Principal Homes
Woodend,
Water Lane
Storrington
RH20 3LY

Please ask for: Nicola Moore
Email: nicola.moore@arun.gov.uk
Telephone: Ext 37944
Our Ref: BN/112/21/PL
Your Ref:
Date: 16th August 2021

Application for Planning Permission

Development: 1 No. 4 bed detached dwelling and associated parking and gardens. This application is within CIL Zone 3 and is CIL Liable as a new dwelling.
Location: Stoneyfield Nursery Eastergate Lane Eastergate PO20 3SL

Block & Site plans 1:500 @ A3 0 5 10 15 20 25

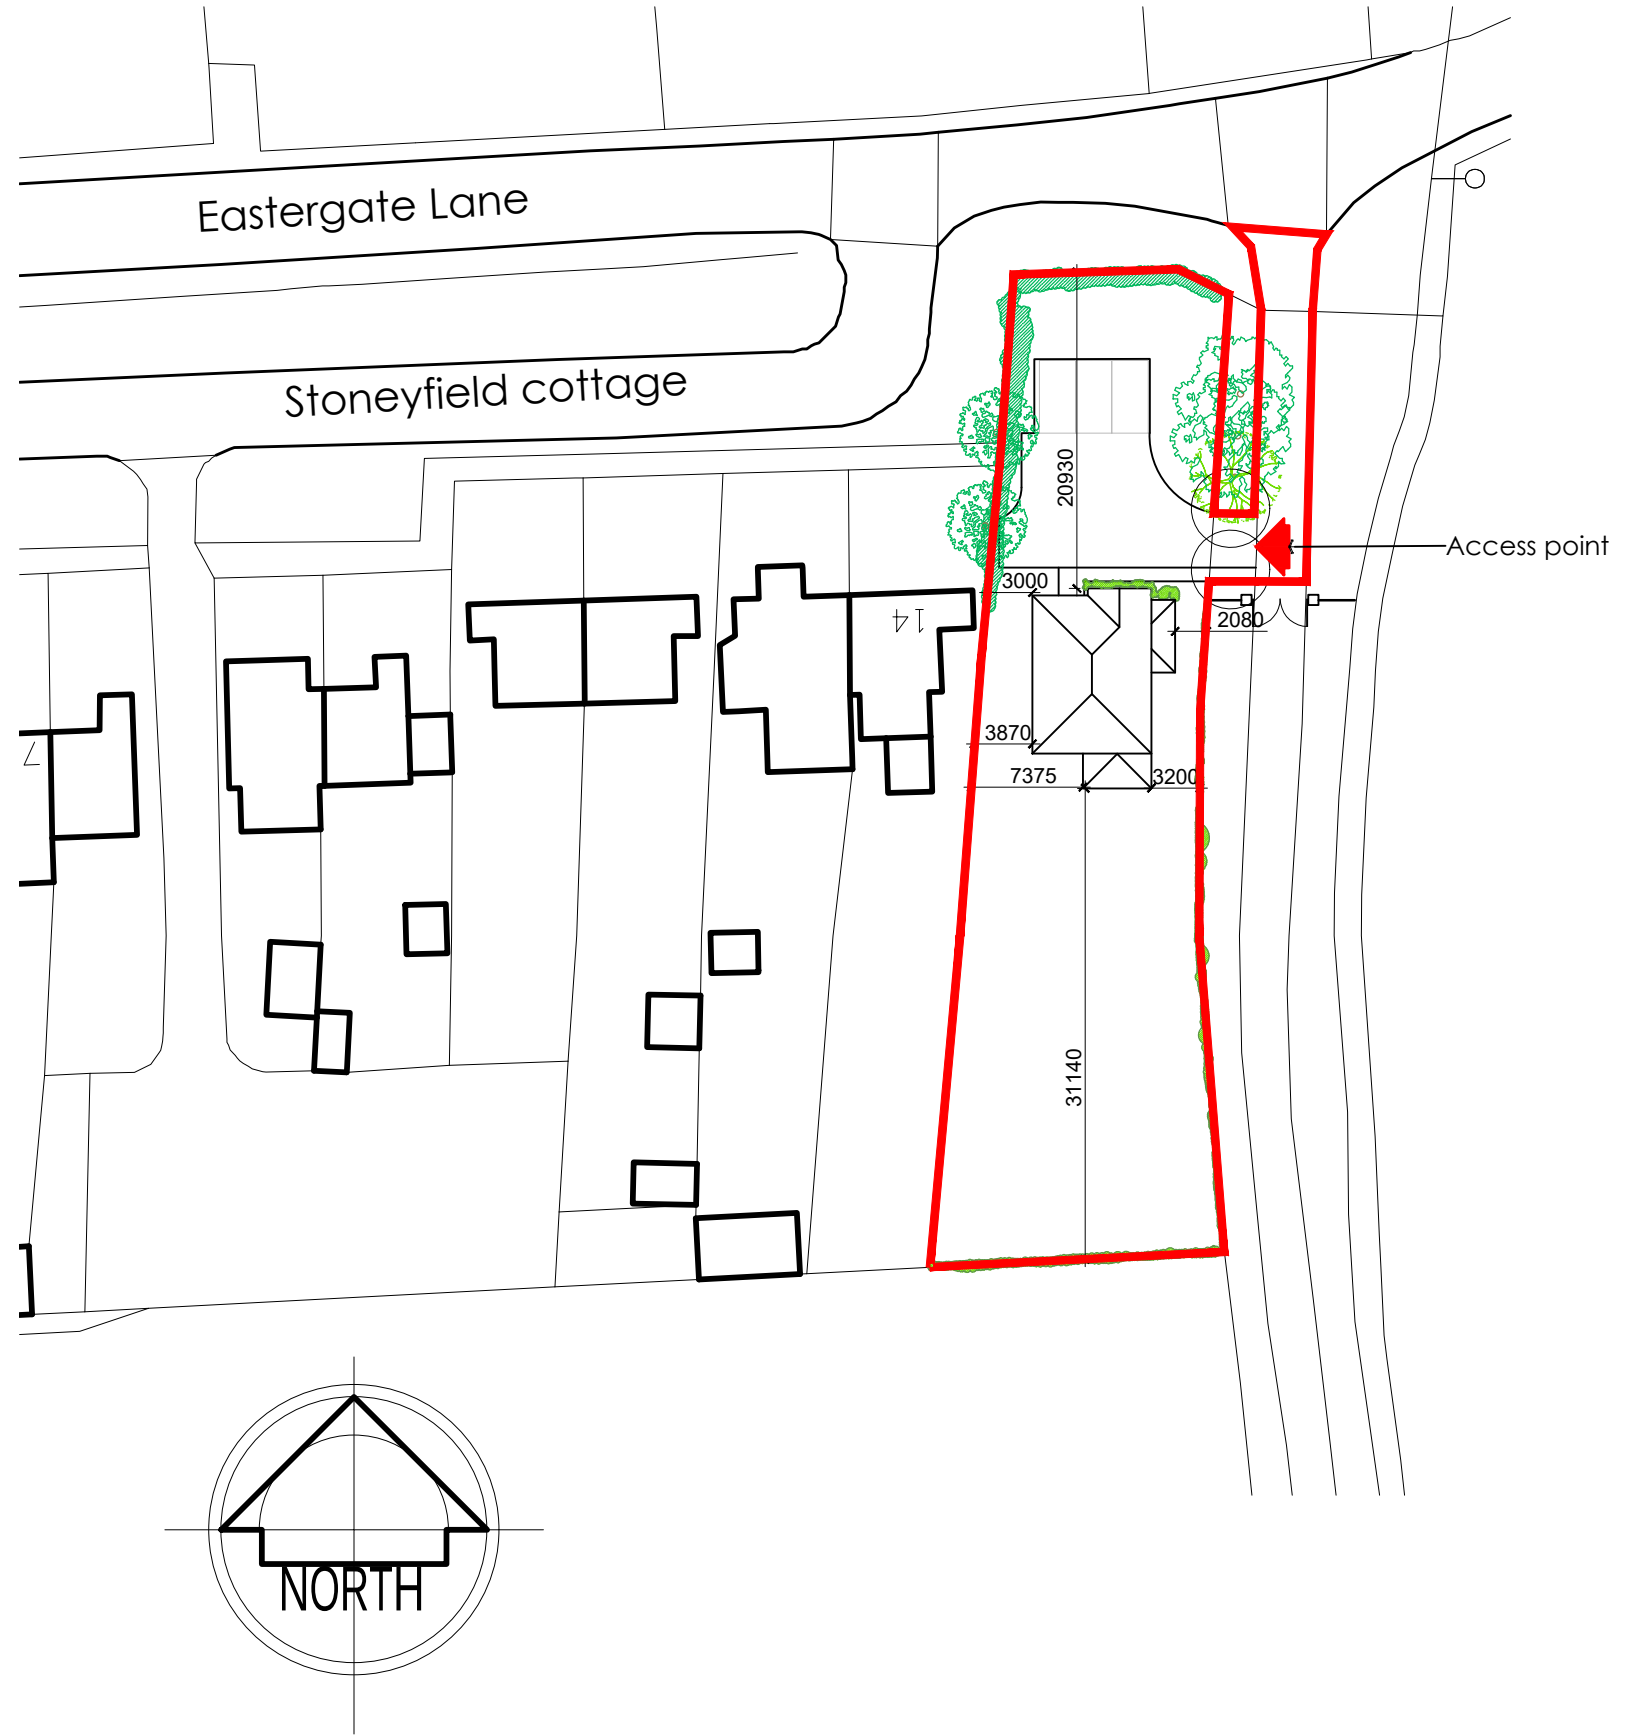
Block Plan

The Block plan should include distances to boundaries from the proposed development. Please amend accordingly and re submit. Further details of what must be included on the plan can be found in the Validation Requirements List.

As existing site section 1:200 @ A3

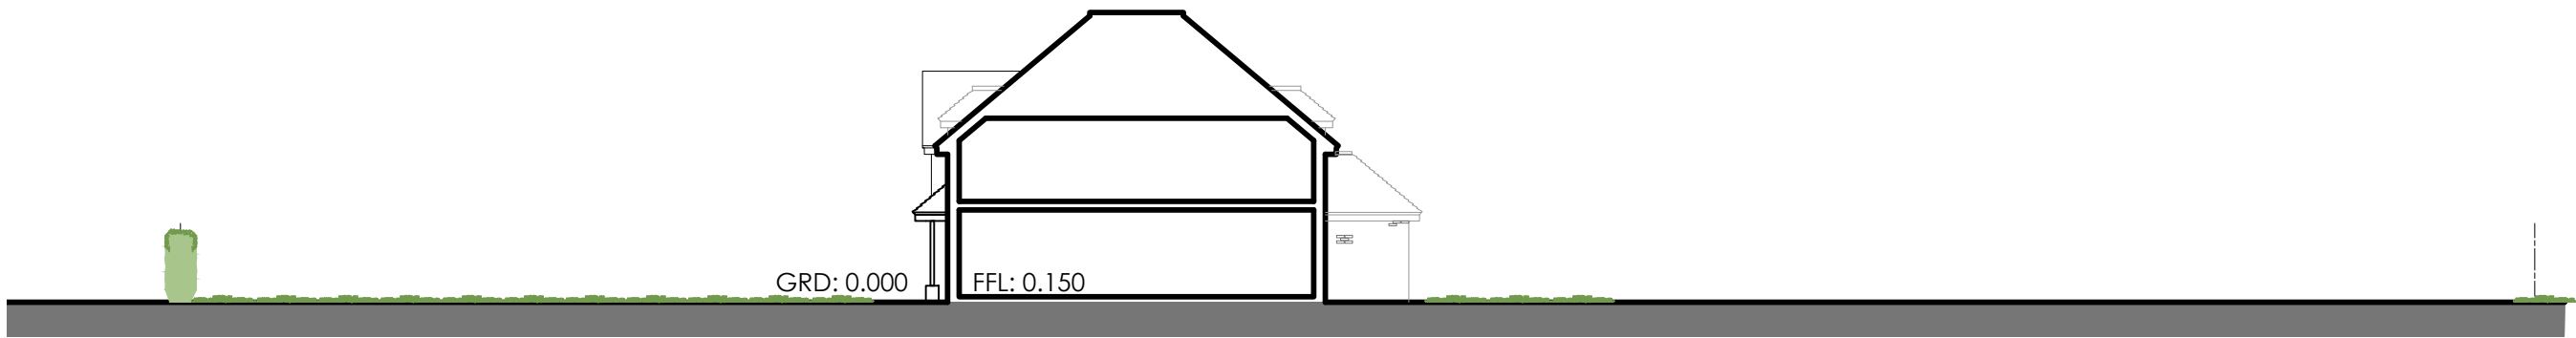
Sections

Please submit 1 electronic or 3 paper copies of existing and proposed sections and finished floor/site levels. Further details can be found in the Validation Requirements List.
